**Change of use from (C3) dwelling to (D1) day nursery
Longacre Bungalow Maypole Lane Yapton**

Thank you for the information you have sent following my previous letter. Unfortunately I am still unable to accept the application as valid until the following matters are resolved:-

Existing West Elevation

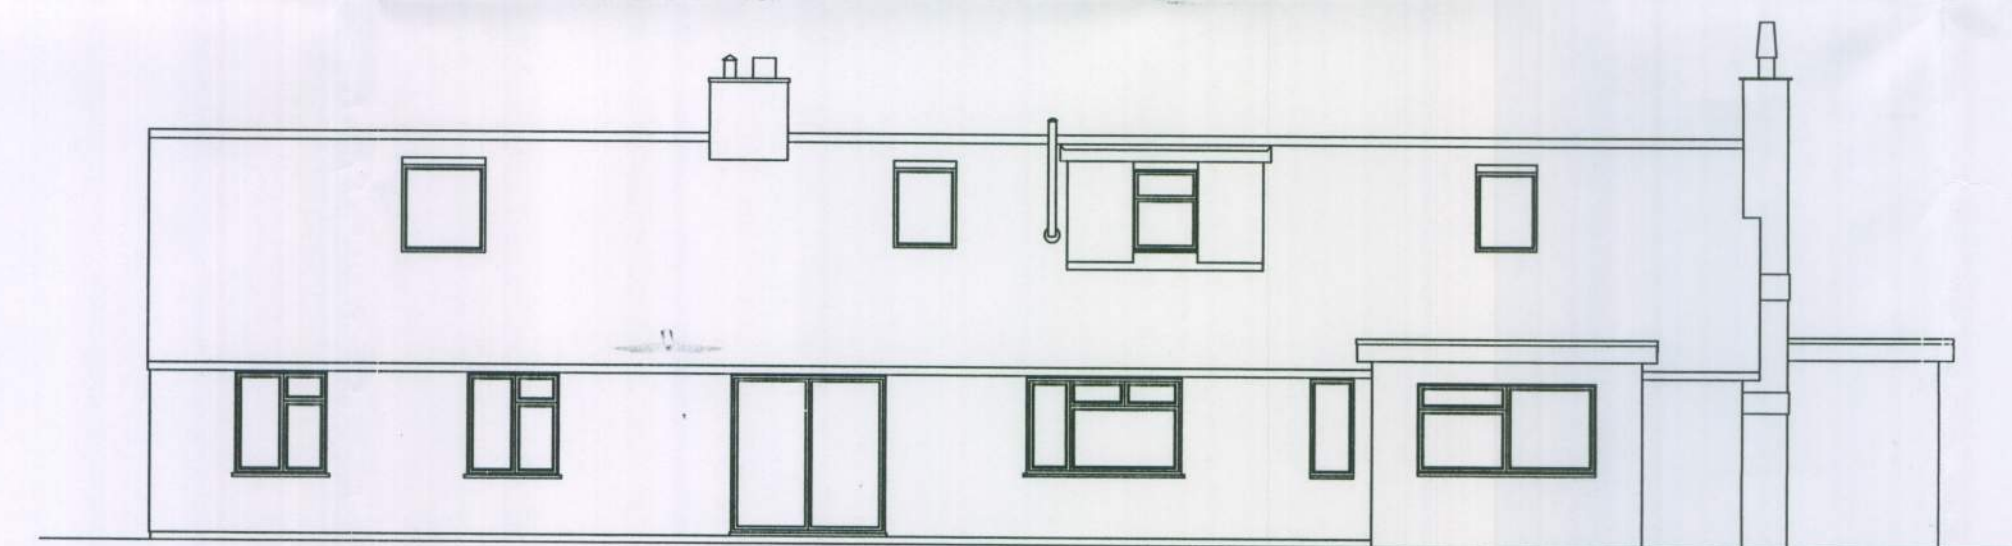
There are 3 rooflights shown on the existing west elevation which are not shown on the existing first floor plan. Please amend.

Proposed East Elevation

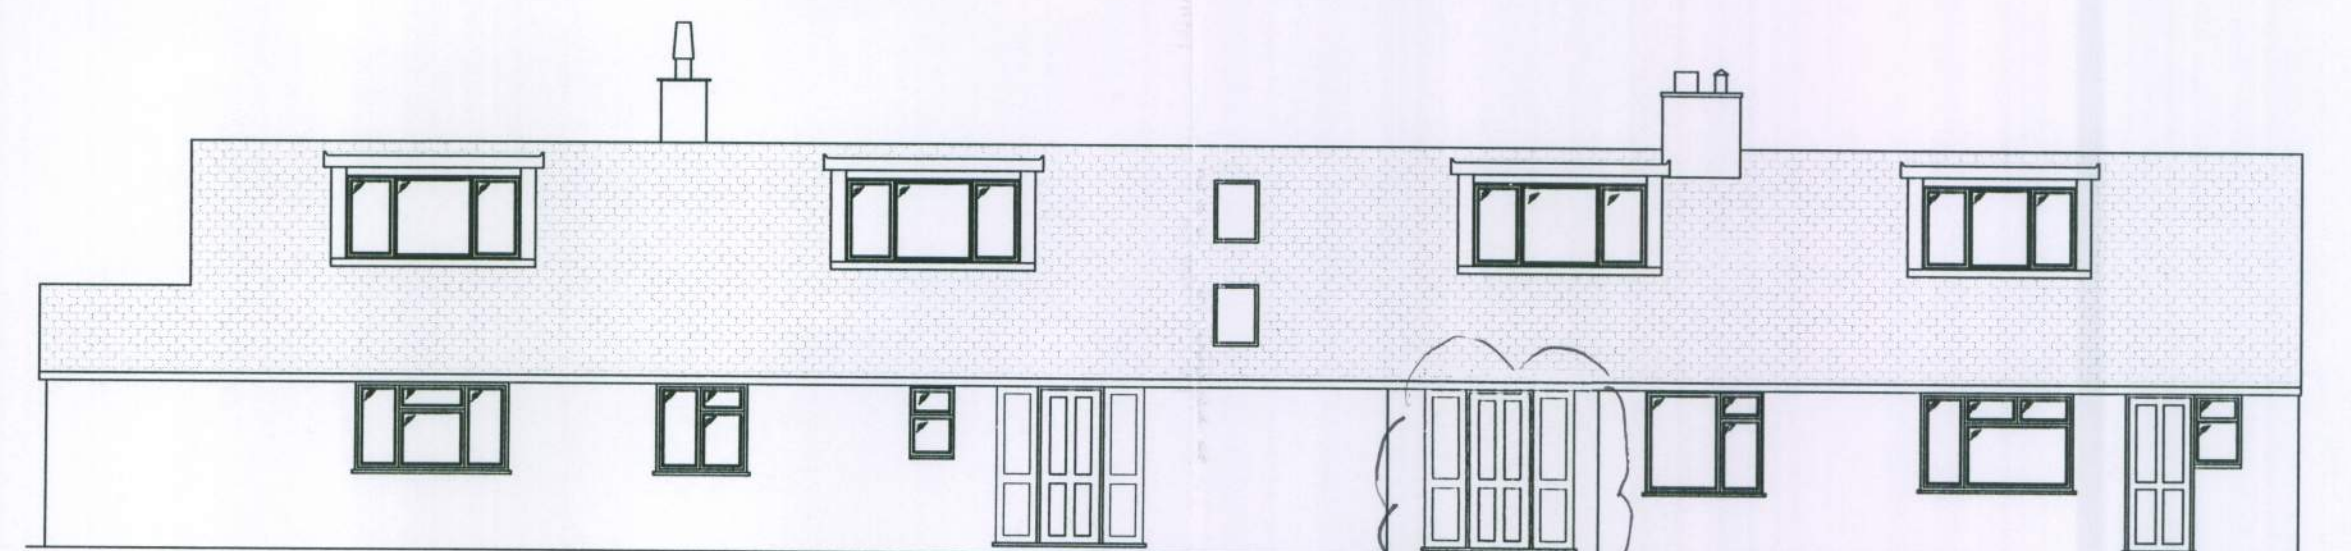
Please confirm that the 2 rooflights referred to in your letter relate to the proposed east elevation. ✓

Proposed West Elevation

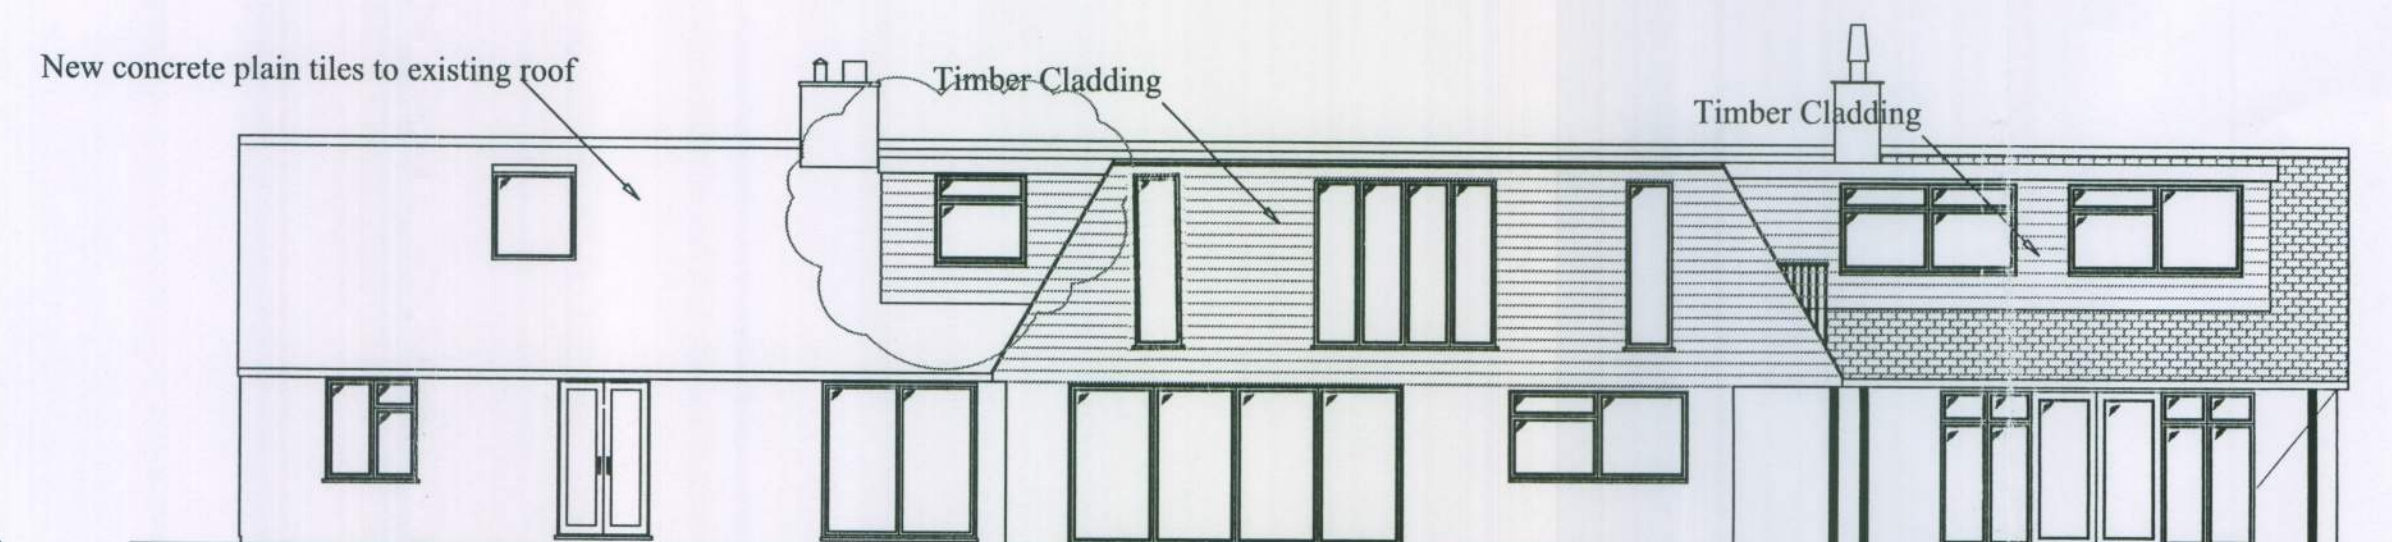
There is a window and a rooflight shown on the proposed west elevation which are not shown on the proposed first floor plan. Please amend.
